CITY OF ALBUQUERQUE

07/24/2018

Re: 1105 Yale Blvd SE
1105 Yale Blvd. SE
Traffic Circulation Layout
Engineer's/Architect's Stamp 07-23-2018 (L15-D062)

1105 YALE BLVD., SE SITE PLAN FOR BUILDING PERMIT			
DRAWING:	DRAWN BY:	DATE:	SHEET #
201821-SP.DWG	SH-B	07-18-2018	1

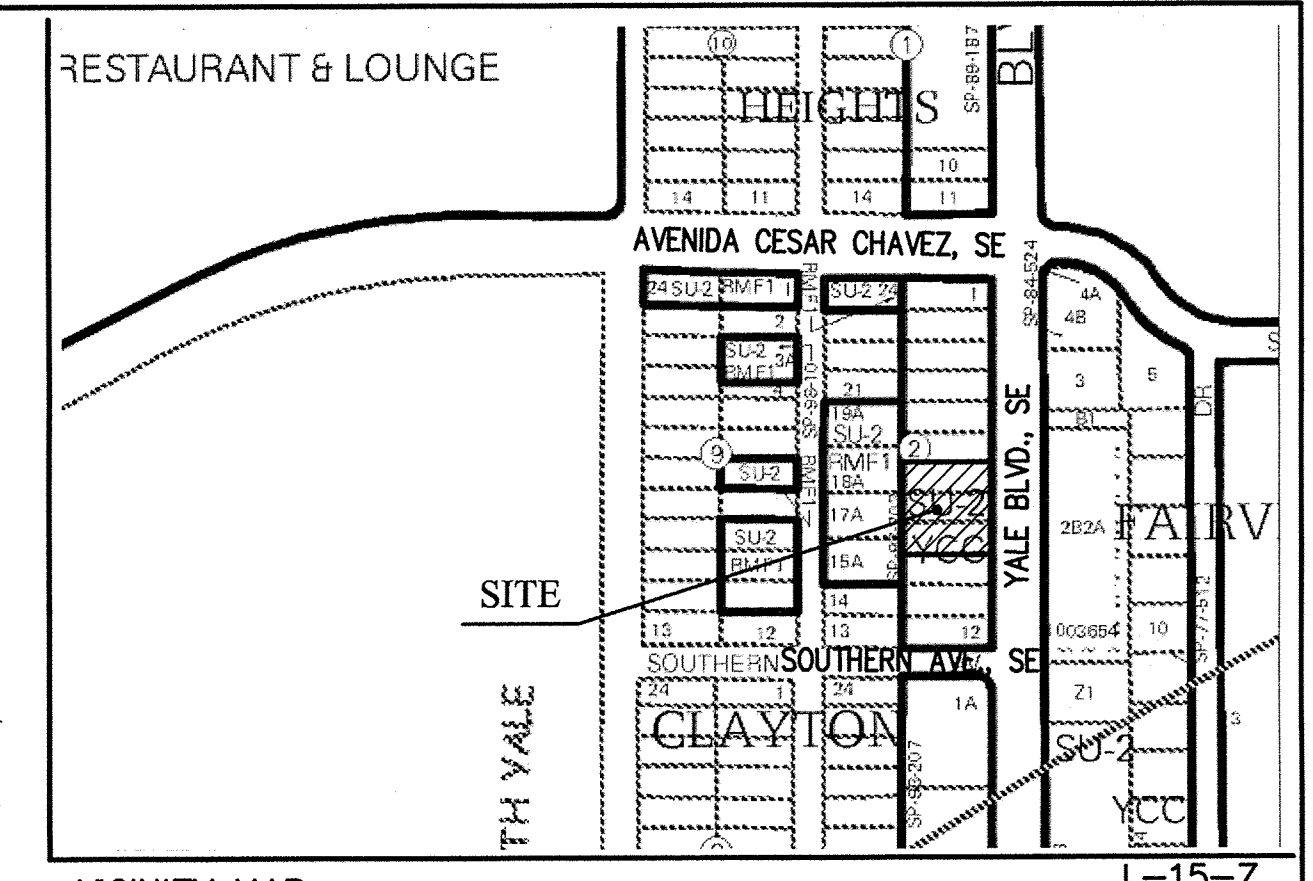
1. Show the clear sight triangle and add the following note to the plan: "Landscaping and signage will not interfere with clear sight requirements. Therefore, signs, walls, trees, and shrubbery between 3 and 8 feet tall (as measured from the gutter pan) will not be acceptable in the clear sight triangle."
2. Please verify the location of garages.
3. Please verify #11.
4. Show the location of the trash cans. It's not clear how the trash cans will be picked up.
5. Replat needs to be completed prior to TCL approval.
6. The width of the driveway needs to be 24 ft instead of 30 ft.
